Application # 0650016029RB

**COUNTY OF HARNETT LAND USE APPLICATION**

**Re: Status of Improvement Permit Application #06-5-16029R  
Colonial Hills Lt 57**

Colonial Hills  
 Lot 57  
 06-500160252  
 RBC Home

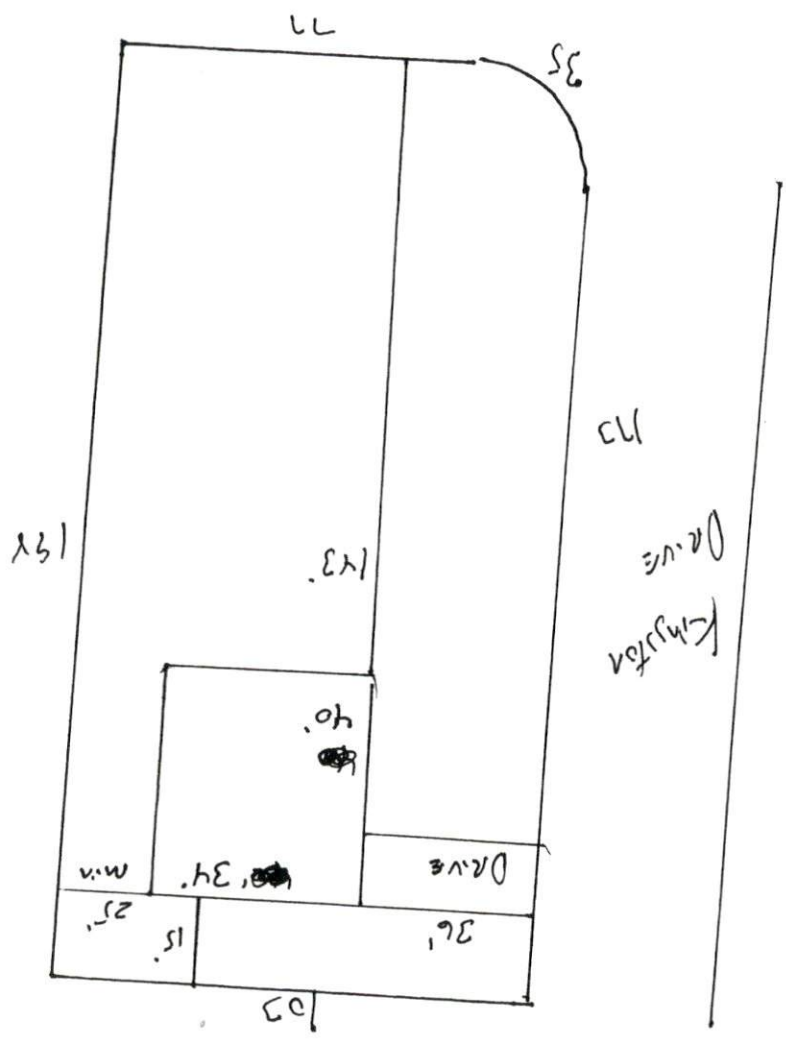
- 1. Property lines/corners not marked or labeled
- 2. House corners not marked or labeled
- 3. Directions not clear to property
- 4. Property needs brush or vegetation removed
- 5. Backhoe pits required
- 6. Other – Move house as shown on the attached sheet. Please send revised plot plan to Central Permitting.
